Application for a non-material amendment following a grant of planning permission.

PROPOSED SINGLE-STOREY & TWO-STOREY EXTENSIONS &
DETACHED DOUBLE GARAGE.

H 08 -0854 -09

8. Non-Material Amendment(s) Sought

DWG NR.
LOC 343.45.09 / 10 A

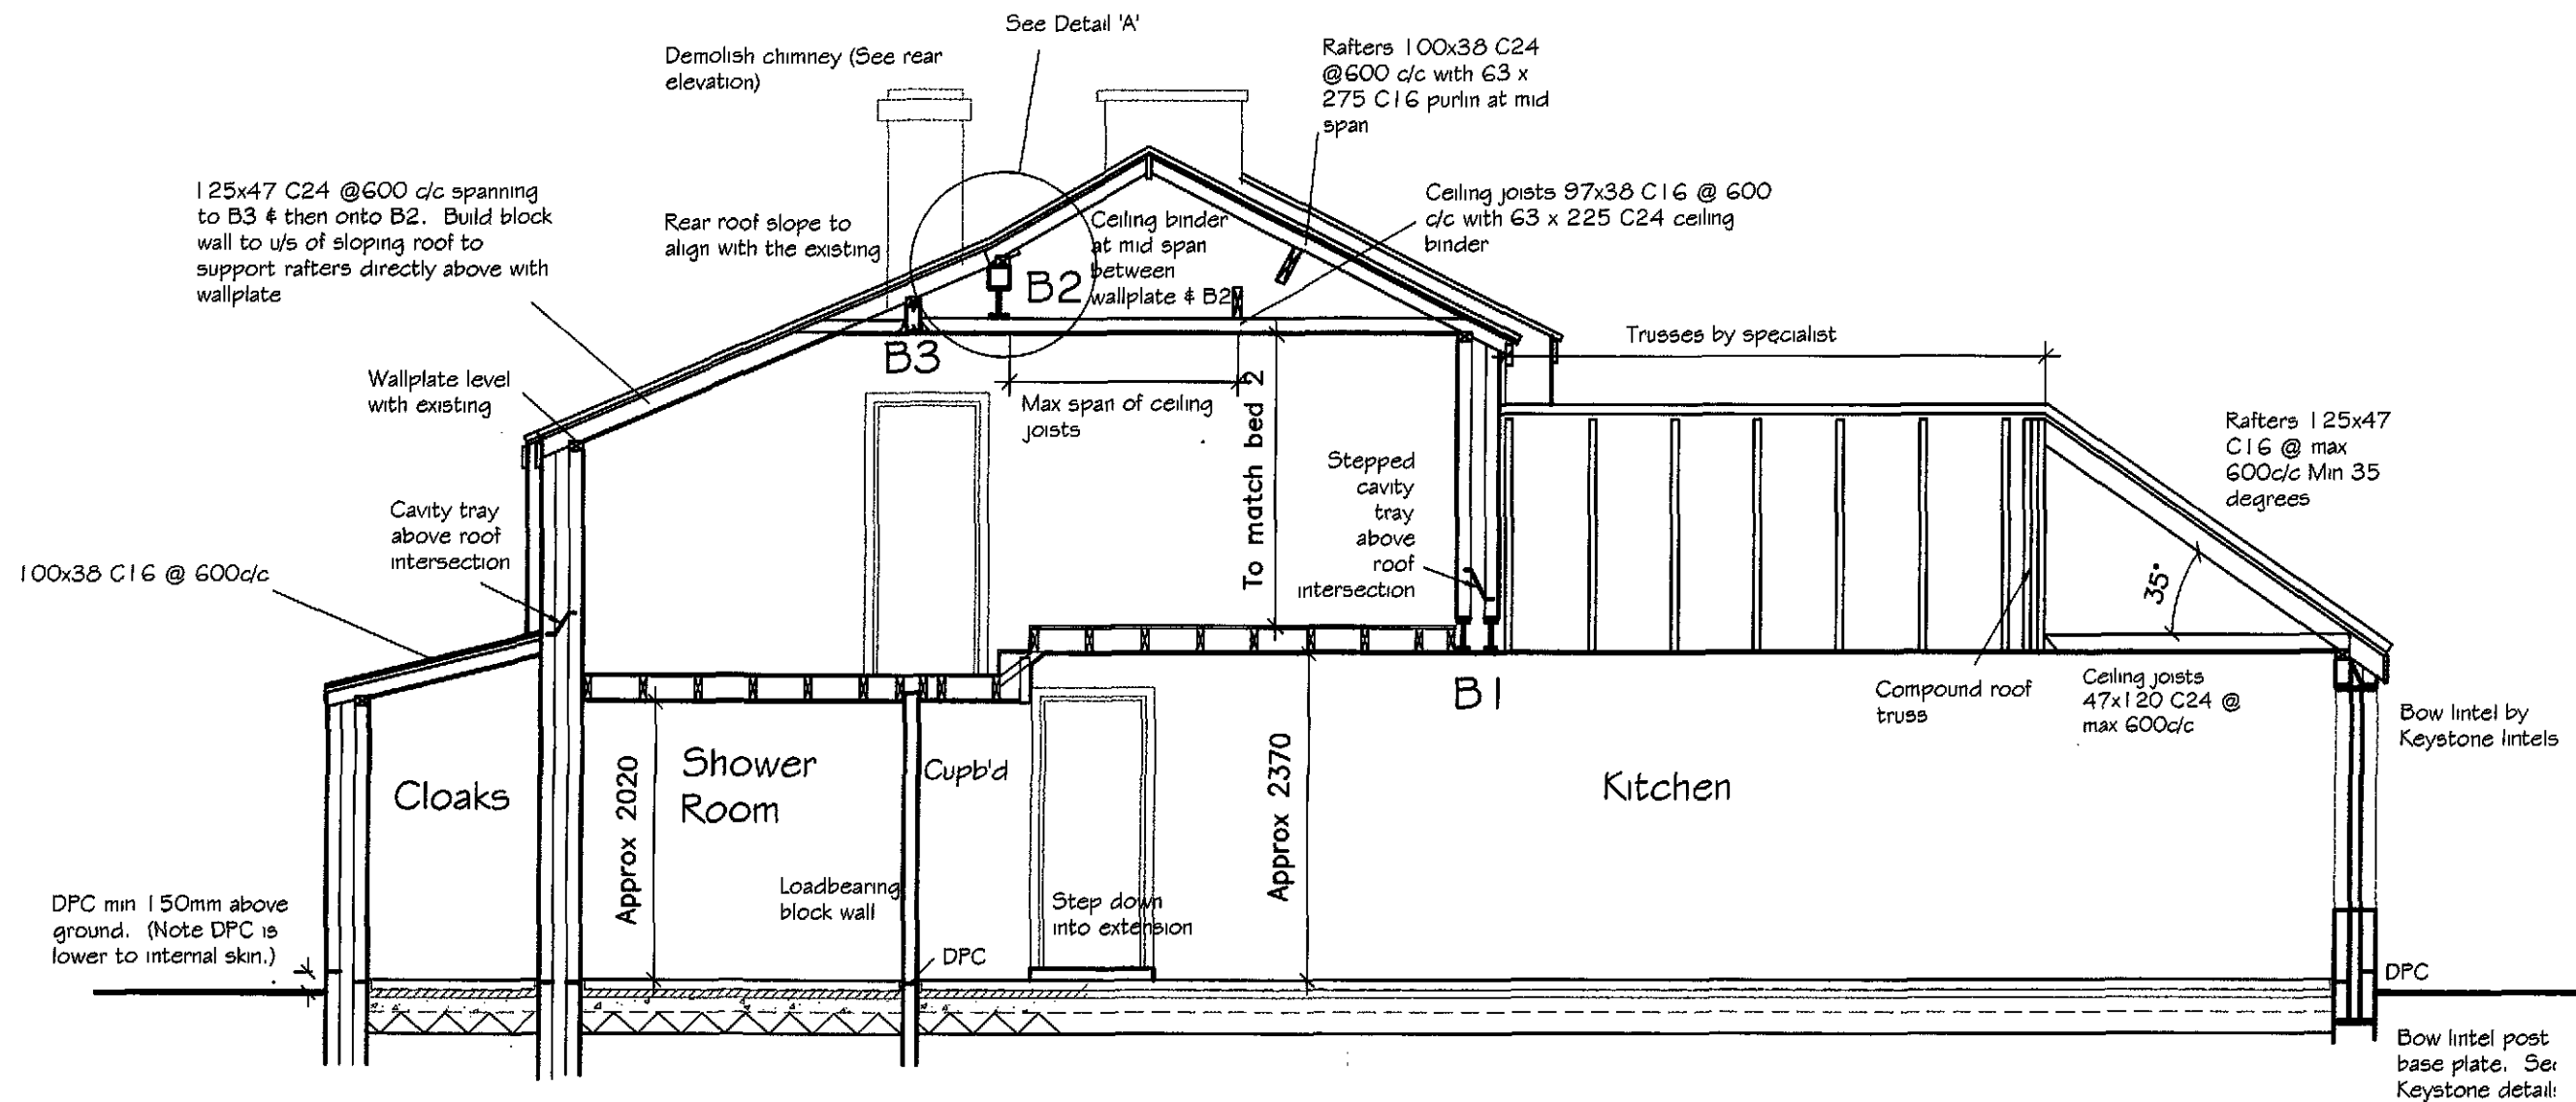
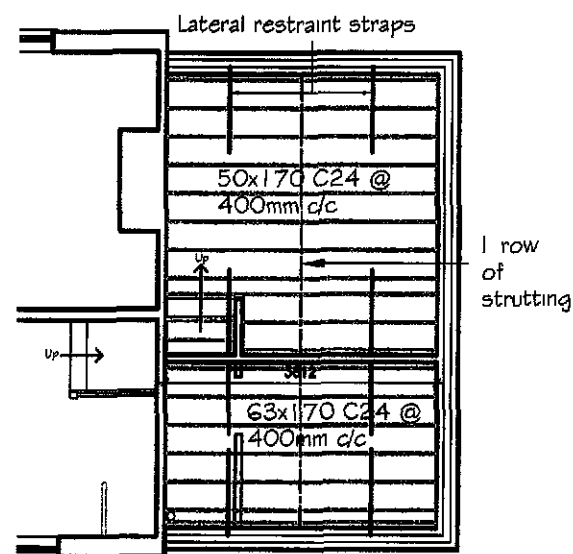
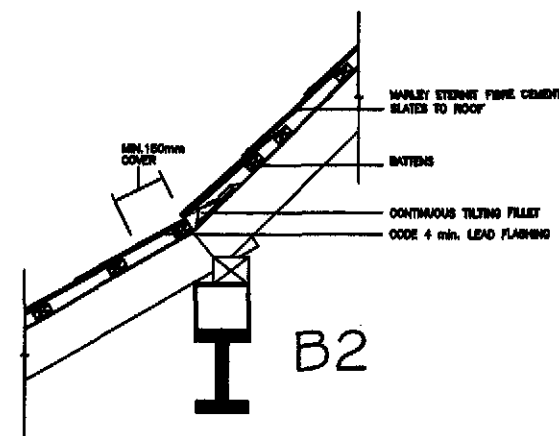
- 4) omit window 6 to first floor (refer to original drawing 343.45.09.109.)

No opening or window now proposed. - Reason - moved the position of the hot water cylinder.

DWG NR.
LOC 343.45.09 / 06 A

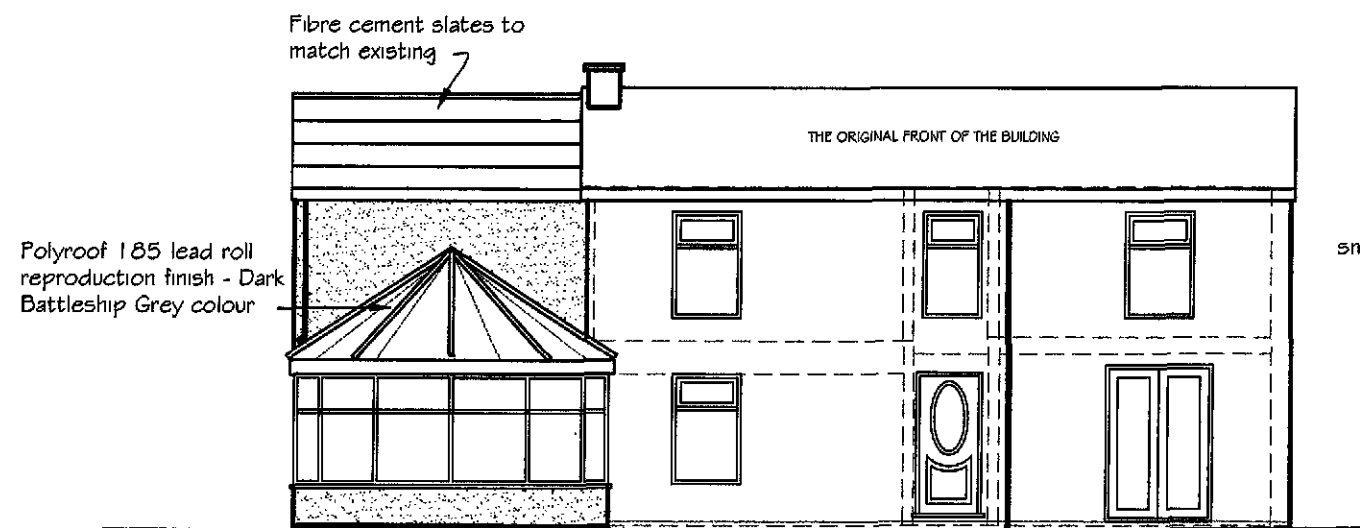
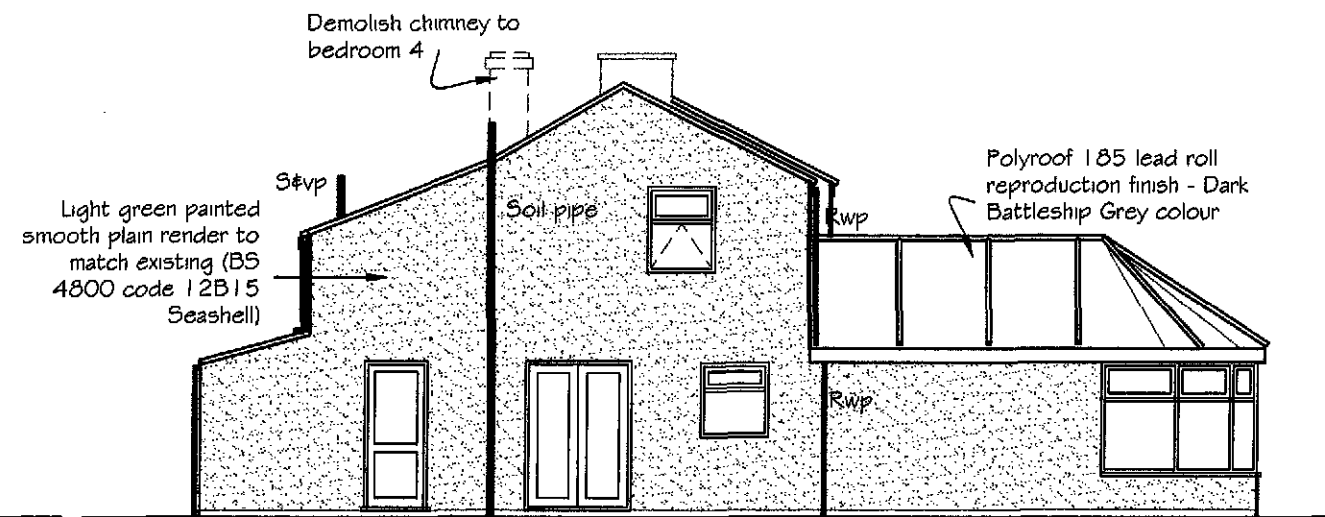
- 1) Colour of PVC-u gutters to main house & extension to be white not black.
- 2) Colour of render to be Johnsons BS4200 code 12B15 seashell to match the main dwelling render.
- 3) omit felt sloping roof to extension & west elevation. omit clay plain tiles to single storey extension - cannot lay these tiles to such a tight radius.
Add to both above mentioned roofs Polyroof 185 lead reproduction finish (GRP) (see also attached sheet)

Existing pitch roof is covered with Eternit fibre cement slates. It is technically not feasible to lay these slates to a radius curved finish to these dimensions. Eternit have said that they will not guarantee their product to this design. This is also the case with using plain tiles. Polyroof however will guarantee this design for 20 years.

Add PVC-U door (white.)

DWG NR.
 LOC 343.45.09 / 08 A

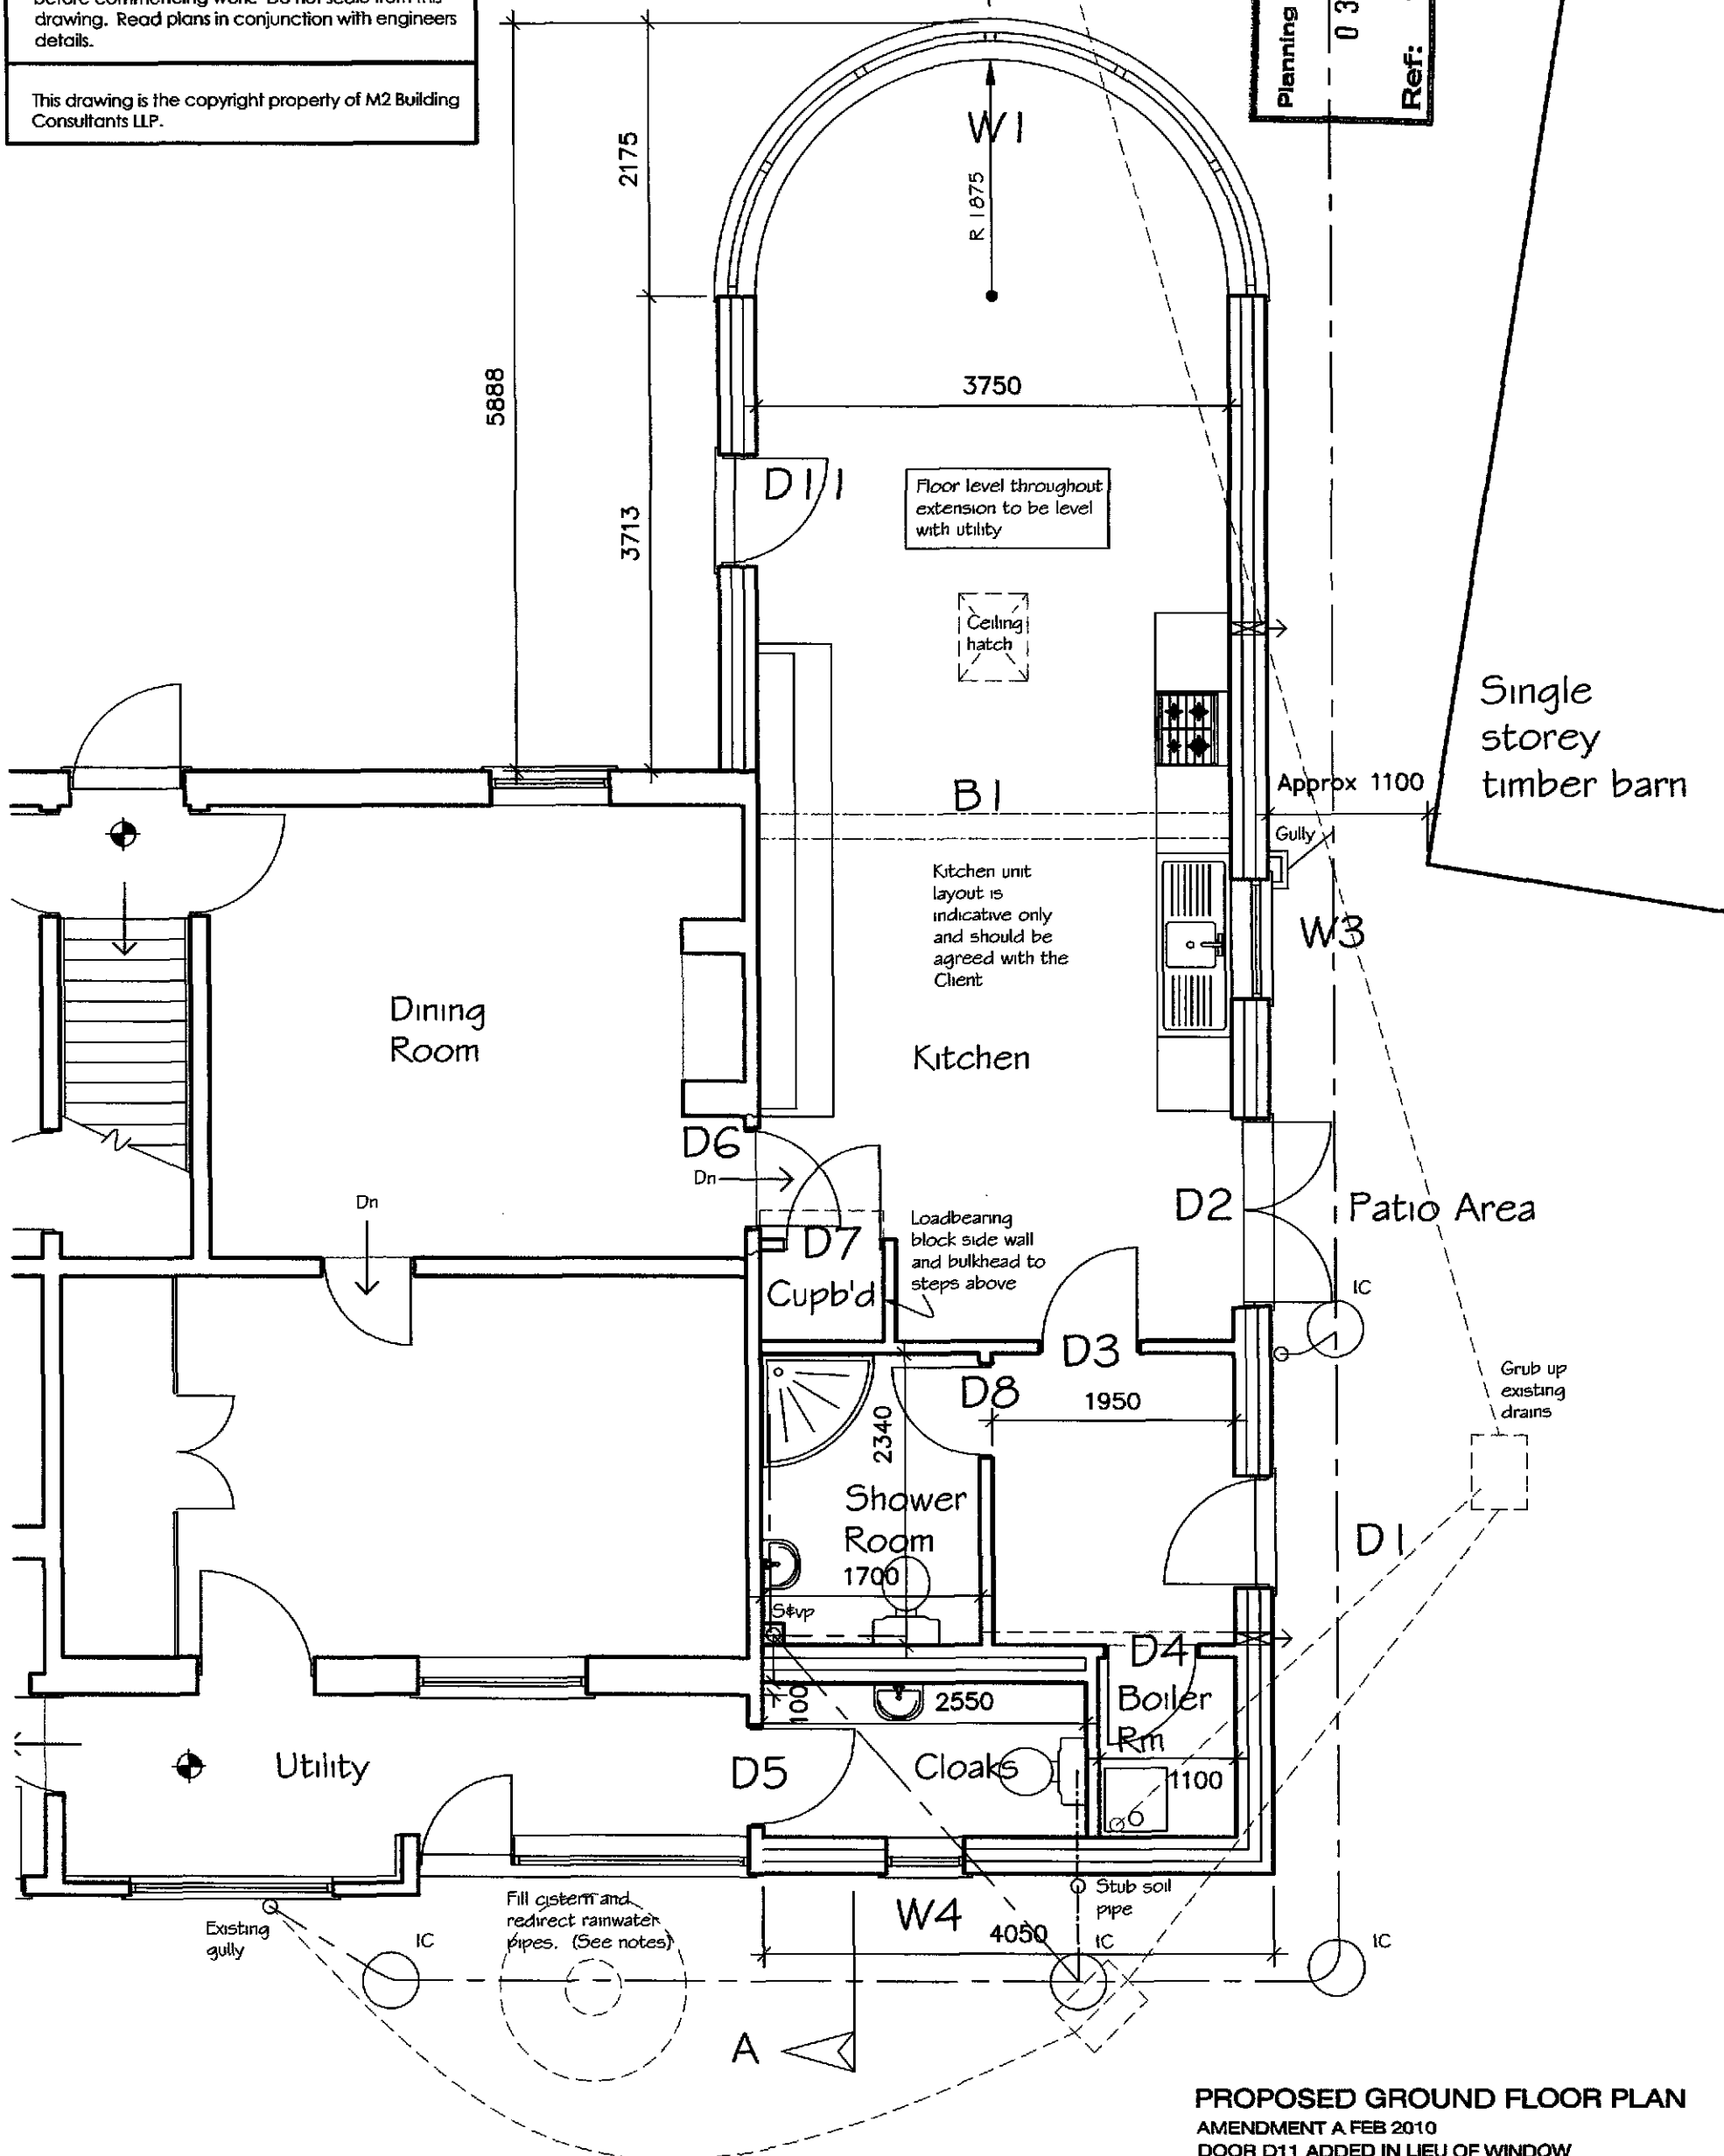
- 5) omit window (W2) to ground floor. (refer to original drawing 343.45.09.108.

Reason - will give direct access to the small enclosed garden adjacent.
